CITY OF PORTLAND, MAINE
HISTORIC PRESERVATION BOARD

April 29, 2013

Re: Exterior Alterations; 46 Avon Street

46 AVON
REAR VIEW

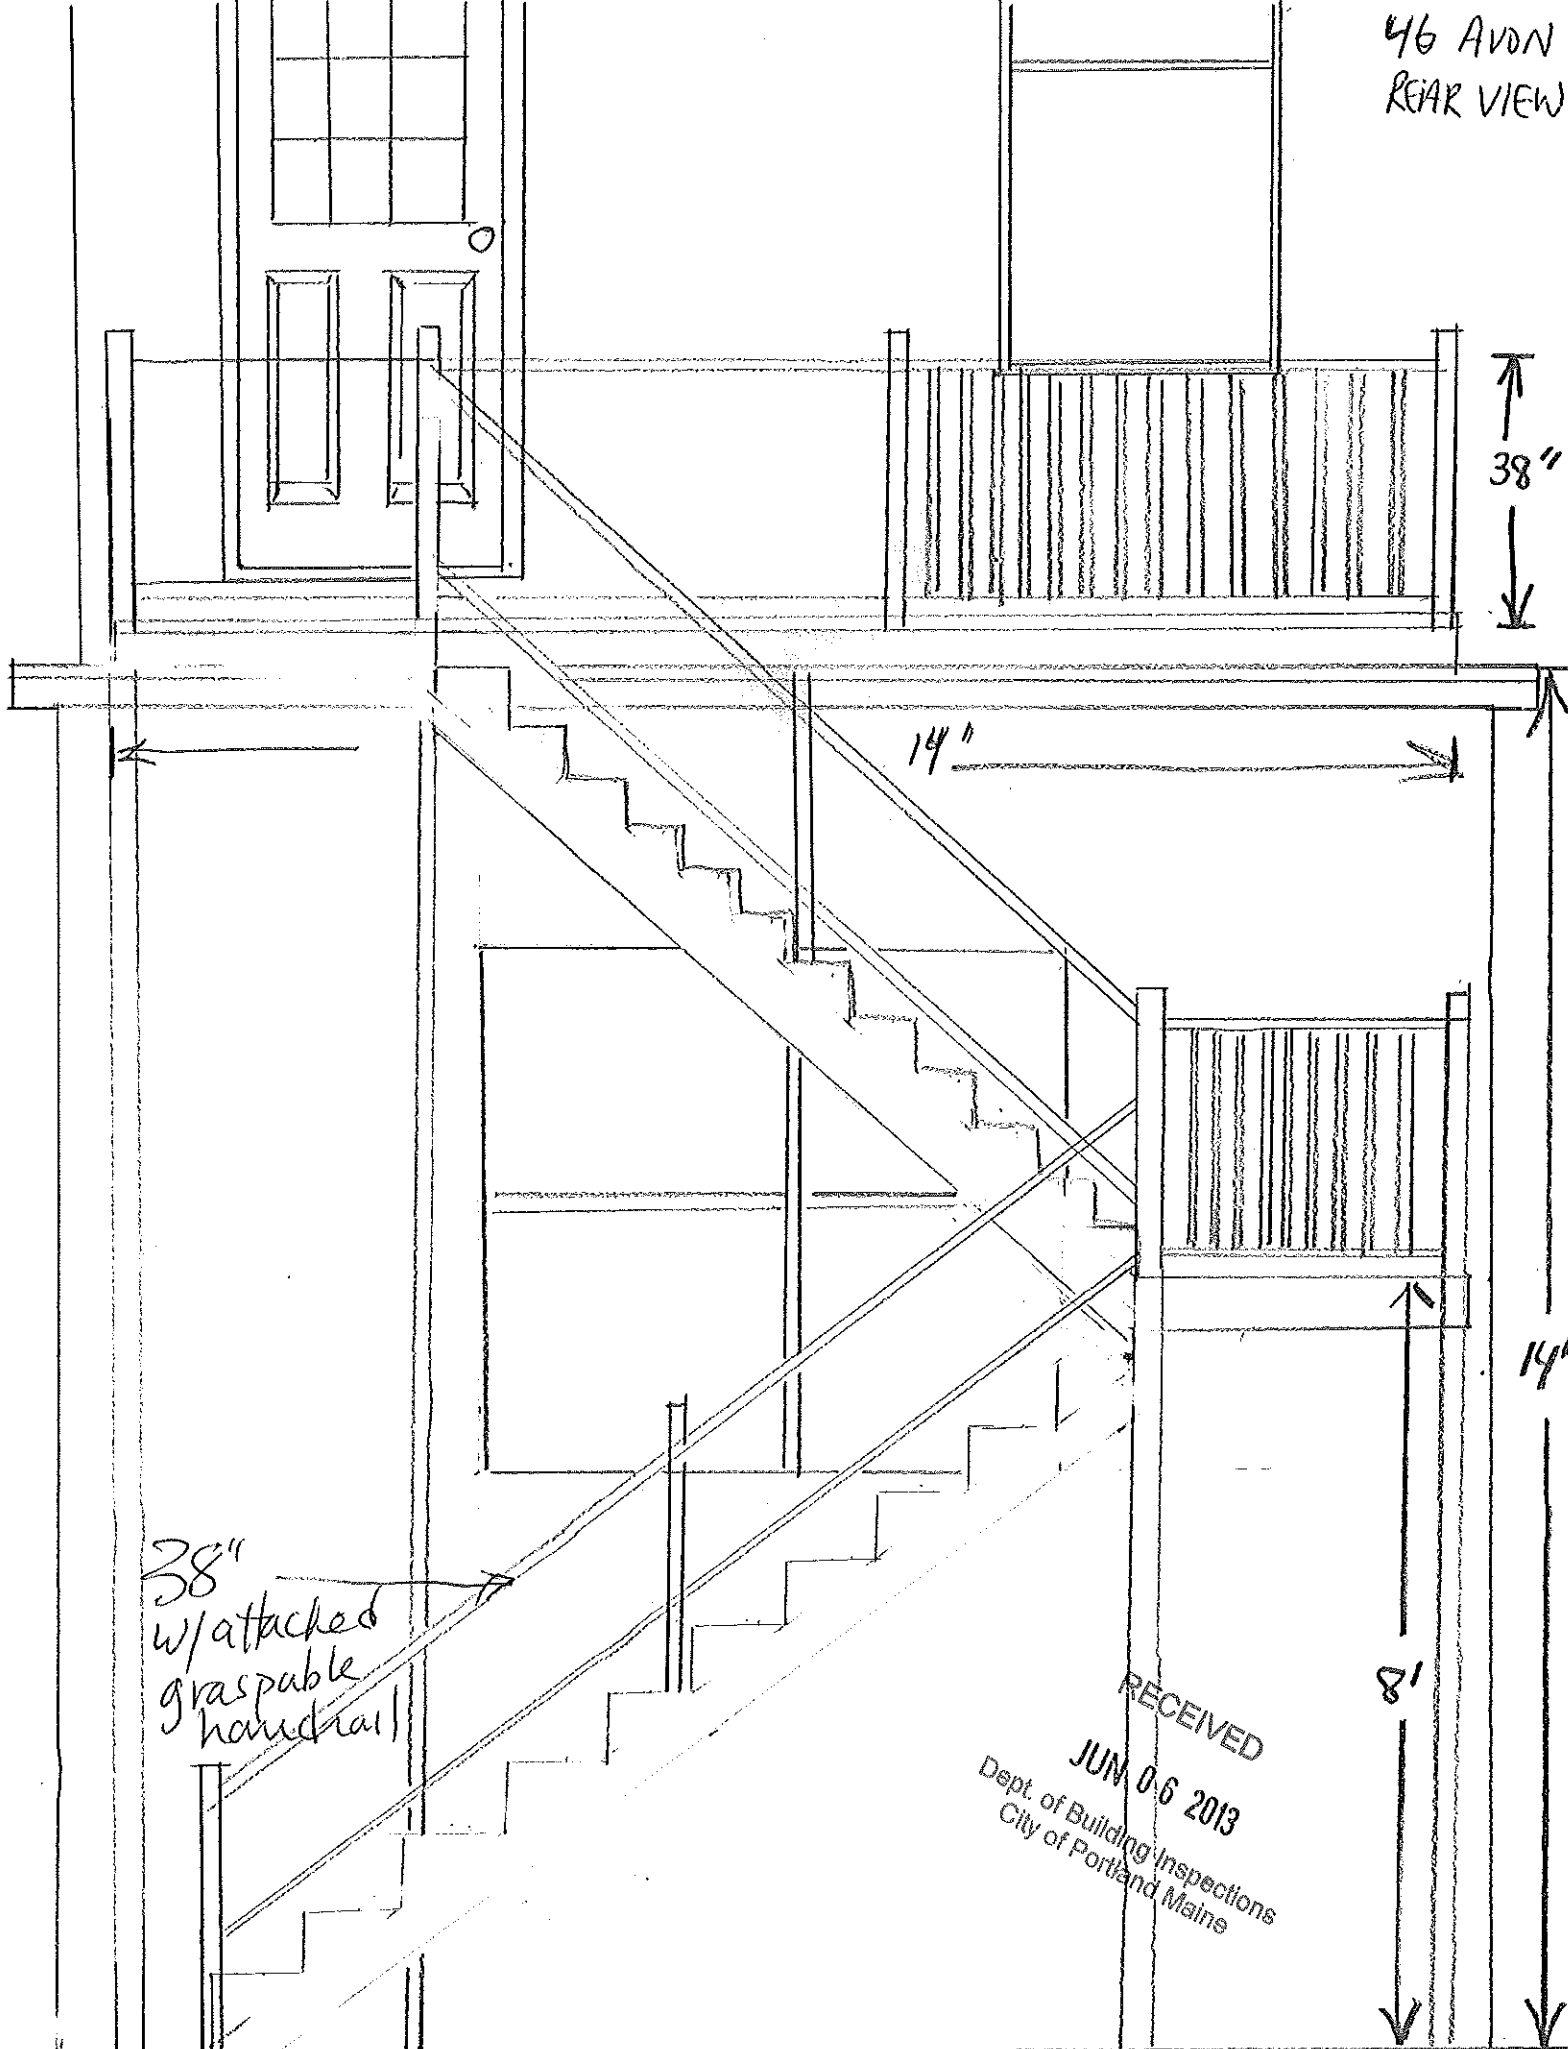
1. Applicant to inform Historic Preservation staff when painting is completed, including pressure-treated stair carriage, risers, and landing framing.
2. Railing system of white vinyl is to include post sleeves and "New England" post caps.
3. Pressure-treated posts supporting landings and stairs shall be wrapped with white painted trim stock.
4. Historic Preservation Board recommends the granting of historic waivers to lower guardrail heights if possible.
